Re: Windermere Final Plat (SF-21-026)

Please accept this response letter to comments received August 10, 2021

Missing Station

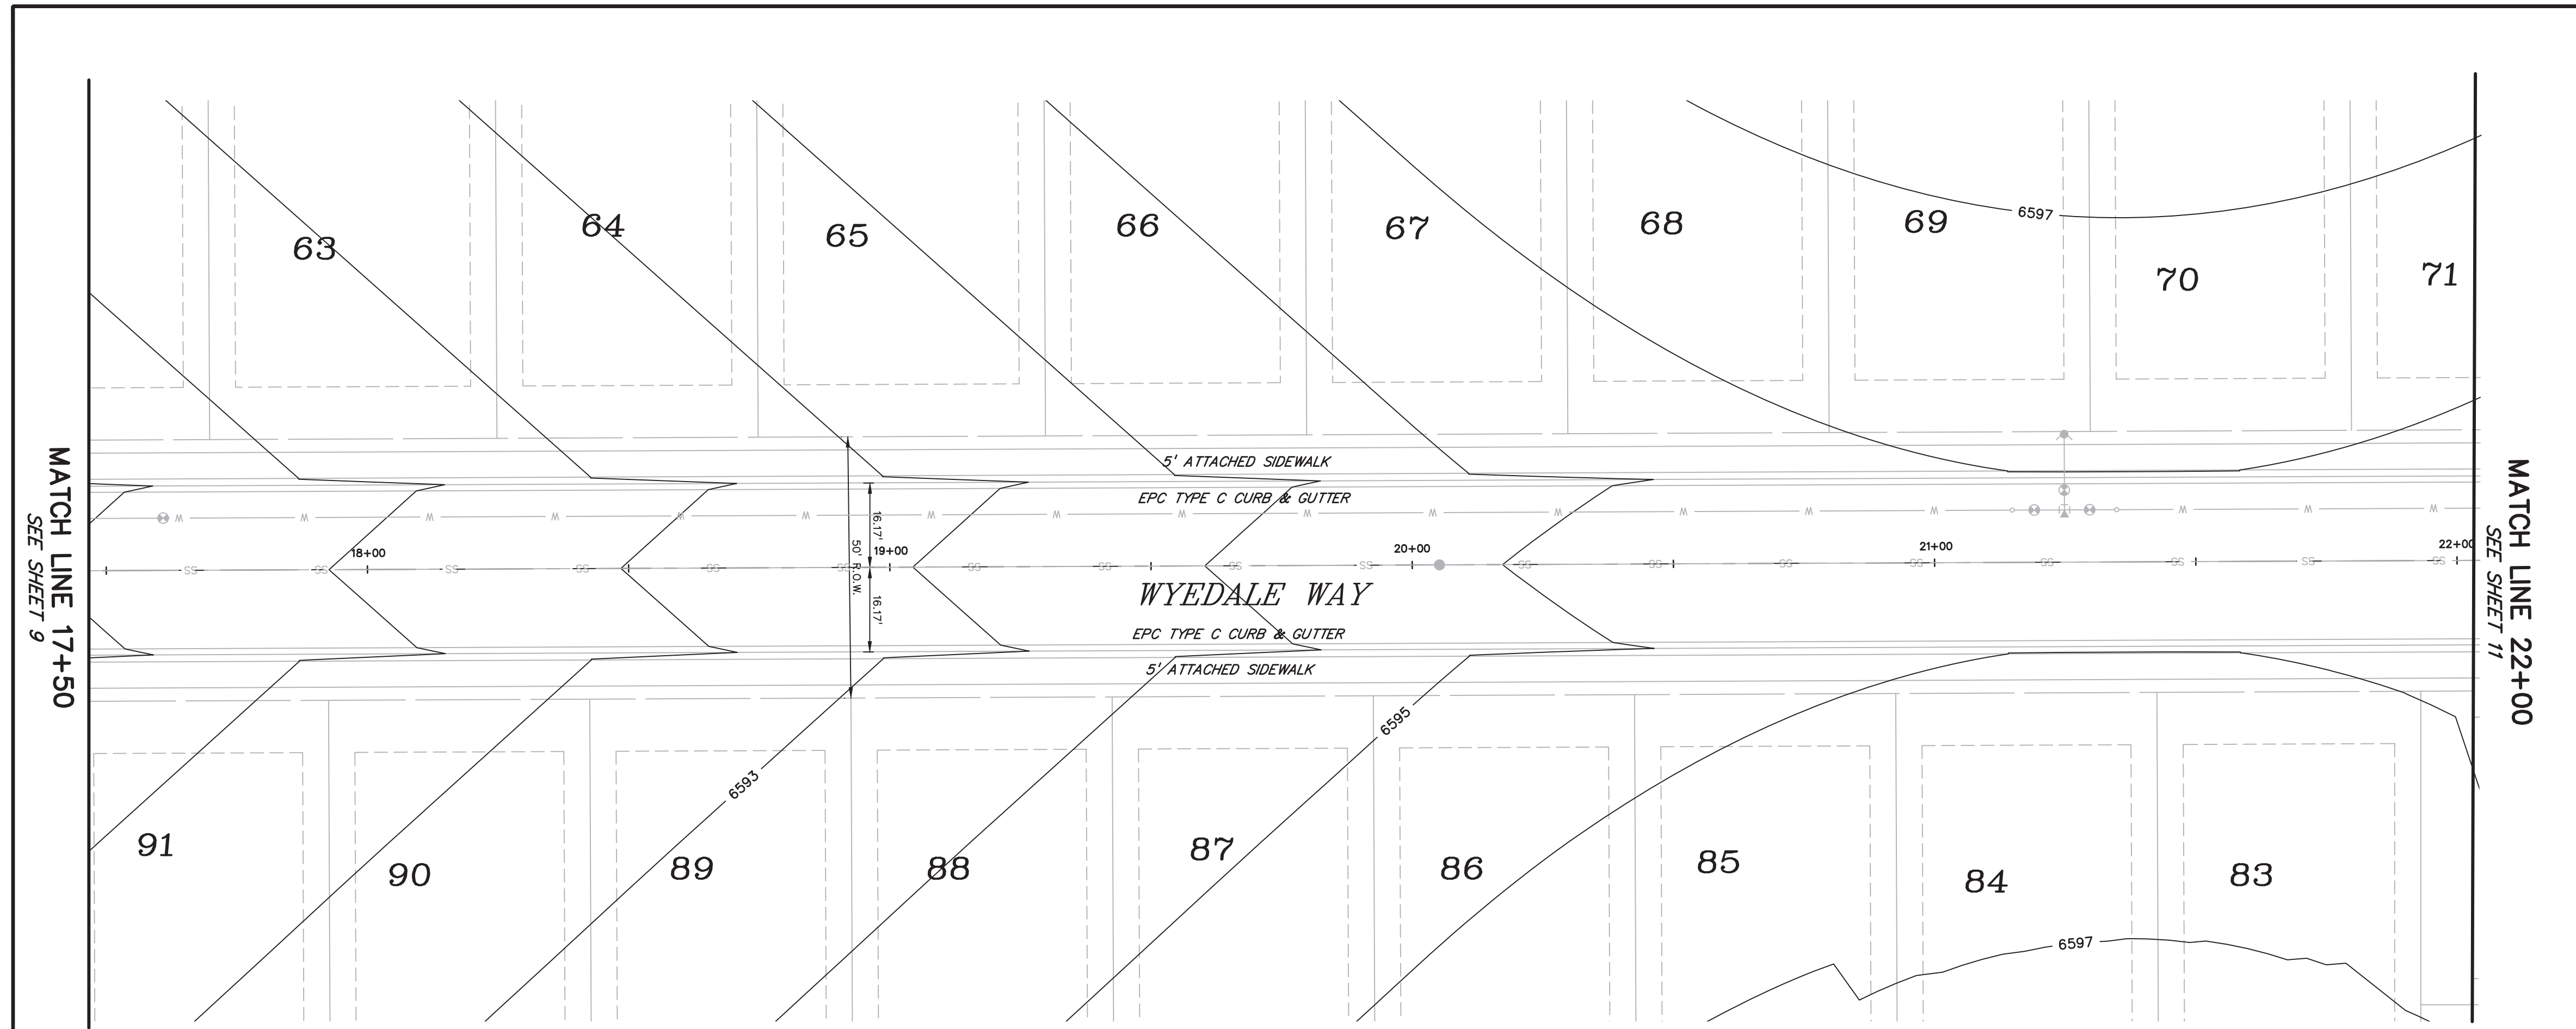
2. See Final Plat comment #2. **Intersection has been revised.**
3. Provide notes specifying watertight pressure pipe (ECM 3.3.1.D - exceeding short runs with a pressure head) where applicable. **Notes added to plans.**
